**From:** Tom Errico <thomas.errico@tylin.com>  
**To:** Jean Fraser <JF@portlandmaine.gov>  
**CC:** David Margolis-Pineo <DMP@portlandmaine.gov>, Katherine Earley <KAS@portlandmaine.gov>, Jeremiah Bartlett <JBartlett@portlandmaine.gov>, Jeff Tarling <JST@portlandmaine.gov>  
**Date:** 12/11/2013 4:13 PM  
**Subject:** 79 Walnut Street - Munjoy Heights

Jean - I have reviewed the revised plans and offer the following final comments as a status report of my November 20, 2013 comments.

DRAWING NO. **C-10**

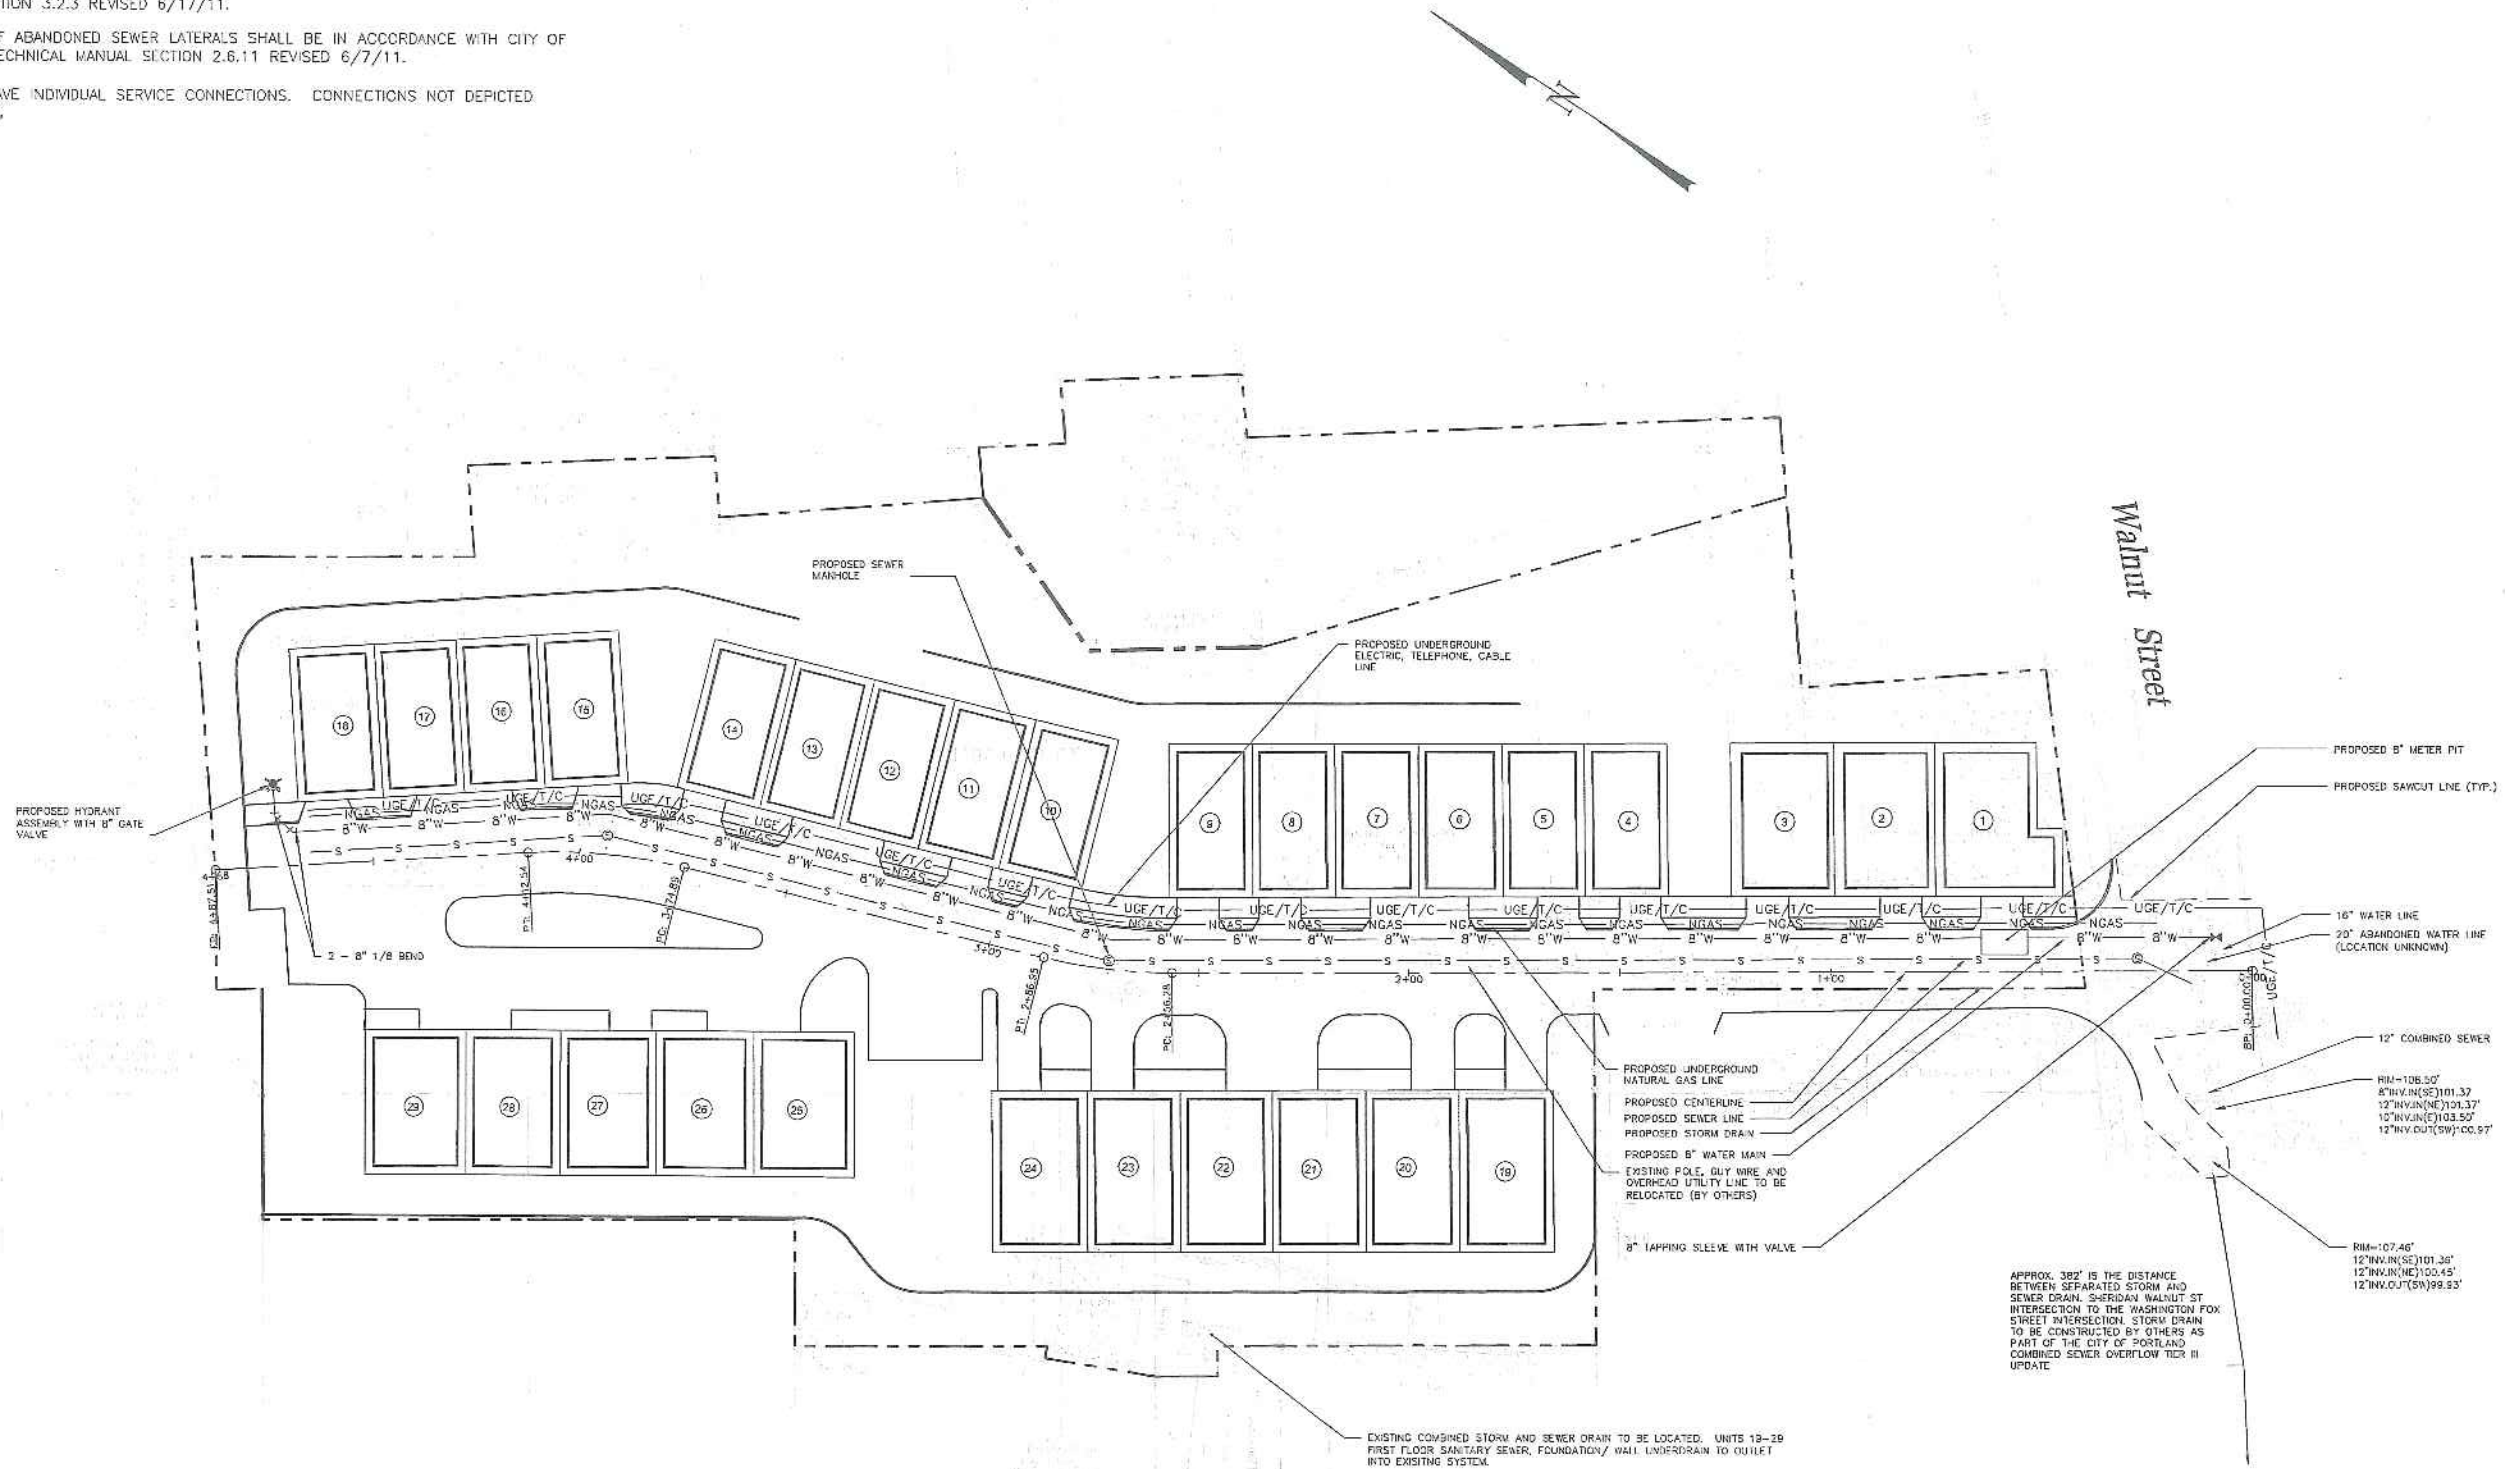
- \* The woonerf design of the roadway sections is acceptable and I believe it will be effective in attaining the goal of a shared use facility. There appears to be some locations where bollards have been added and feedback on the need should be provided.

- \* How visitor parking is accommodated on site needs further consideration given that the parking spaces will be located where pedestrian activity is expected to be high.

- \* The applicant should provide information on the radii size at Walnut Street and whether a smaller configuration will work.

- \* The City plows the sidewalk on Walnut Street in conjunction with the school walking needs. Accordingly, the driveway entrance area will need to accommodate City sidewalk plows. The applicant shall coordinate with DPS on this issue.

- \* **Vehicles shall be prohibited from parking in front of garages for units 1 through 11 due to encroachment into the 20-foot circulation required by the Fire Department. I will leave it to other City staff to best determine how to ensure this restriction is noted.**

**Status: The bollards will create maintenance difficulties, but I find conditions to be acceptable.**

**Status: The general location of the parking spaces is acceptable although I support adjusting the locations to better integrate with the stairs leading to the Jack Trail and East Cove Street.**

**Status: It is recommended that the radii be eliminated from the plans and standard tip down curbing be provided. This change deviates for City standards, but I support a waiver from our technical standards to allow for optimal sidewalk alignment along Walnut Street and to ensure easier routing of sidewalk snow plows (this subject sidewalk is a school walking route and maintenance and function are a priority).**

**Status: As noted above, tip-down curbing shall be installed and accordingly this issue has been addressed. Final plans shall be reviewed and approved by DPS.**
